Please ask for: Ms Iqraa Malik
Email: iqraa.malik@terraquest.co.uk
Telephone: 0121 234 1390
Our Ref: M/20/22/HH
Your Ref:
Date: 1st March 2022

Application for Planning Permission for Works or Extension to a Dwelling

Development: The construction of an additional storey, rear single storey extension and detached garden building.
Location: 48 Lane End Road Middleton-On-Sea PO22 6LT

Proposed Site / Block Plan
1:500 @ A3

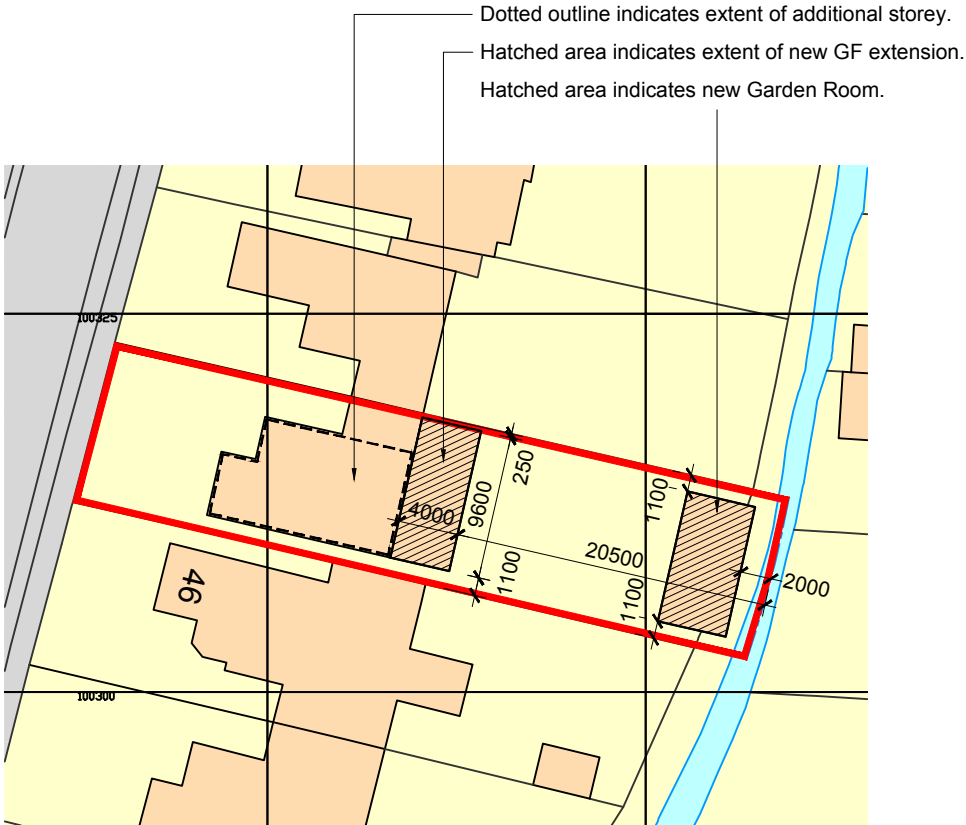
Please add the dimension from the proposed rear extension to the rear boundary on the proposed block plan scaled 1:500. Further details of what must be included on the plan can be found in the Validation Requirements List.
